**Subject: Griffith Battery Energy Storage System (SSD 85372970)**

Thank you for your email dated 19 November 2025 seeking advice from the Regional Delivery (RD) of the NSW Department of Climate Change, Energy, the Environment and Water about the Environmental Impact Statement (EIS).

ATTACHMENT A – RD Assessment Summary for Griffith BESS EIS (SSD 85372970)

## **ATTACHMENT B Detailed advice for Griffith BESS EIS (SSD 85372970)**

The existing-condition flood depths and water surface elevations (WSE) for the 0.2% AEP event are presented Figure 6 and Figure 7.

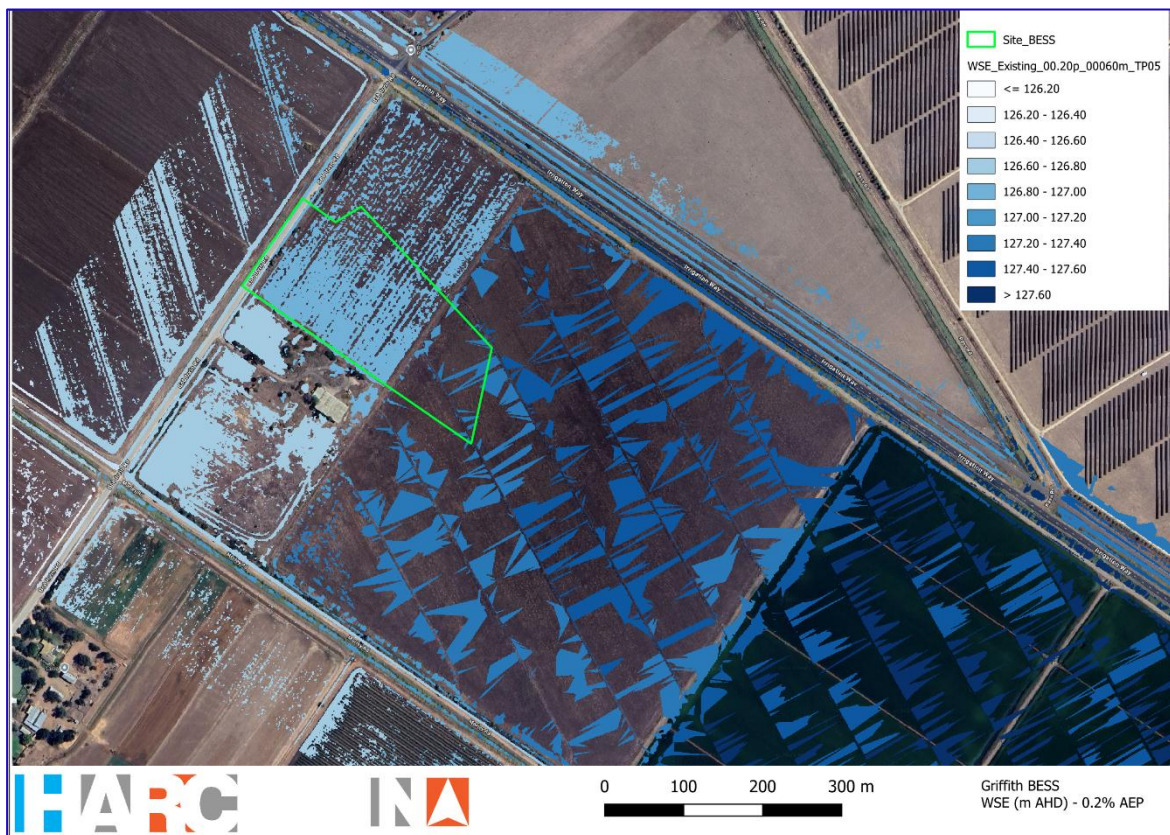
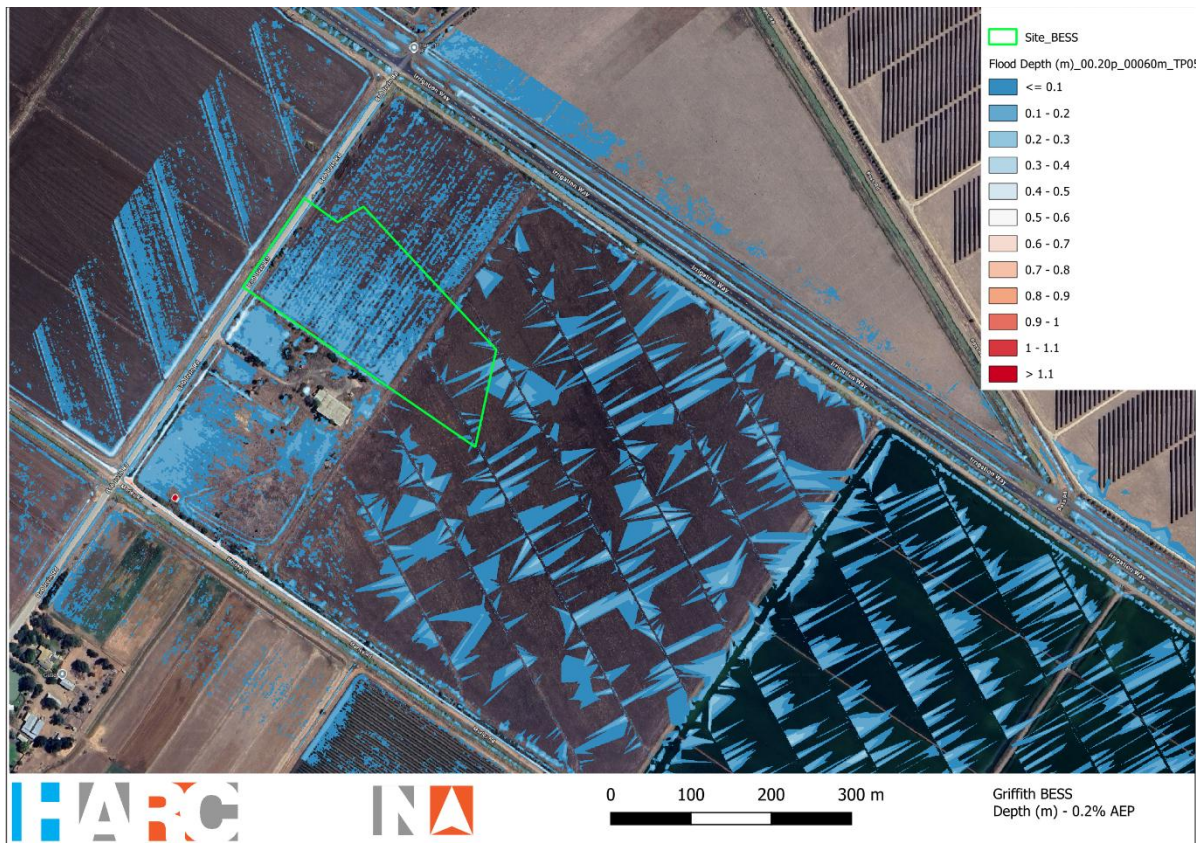
The assessment of flood risk presented in the Hydrology Assessment is largely conceptual and does not consider the impact of flooding on the proposed development. The focus of the assessment was on limiting the flows external to the site to pre-development conditions, while not considering the impacts of flooding on the project infrastructure within the site.

The full range of flood risks up to and including the probable maximum flood (PMF) need to be assessed as required by the SEARs. This is largely to ensure that sensitive site infrastructure is located and elevated to a level that minimises flood risk.

There is no mention of the proposed elevation of critical and sensitive infrastructure above design flood levels in the EIS. This must be further investigated in the detailed design phase of the project.

RD recommends that once finalised, the detailed design be incorporated into the hydraulic model to accurately investigate these issues. The outcomes of the additional modelling should be documented in an updated Hydrology Assessment and confirm that flood risks have not increased or changed significantly because of incorporating the detailed design.

- 1.1. Incorporate the detailed design of the project into the hydraulic model to accurately investigate the impact of flooding on the proposed development.
- 1.2. Ensure that critical and sensitive infrastructure are elevated sufficiently to minimise flood risks.
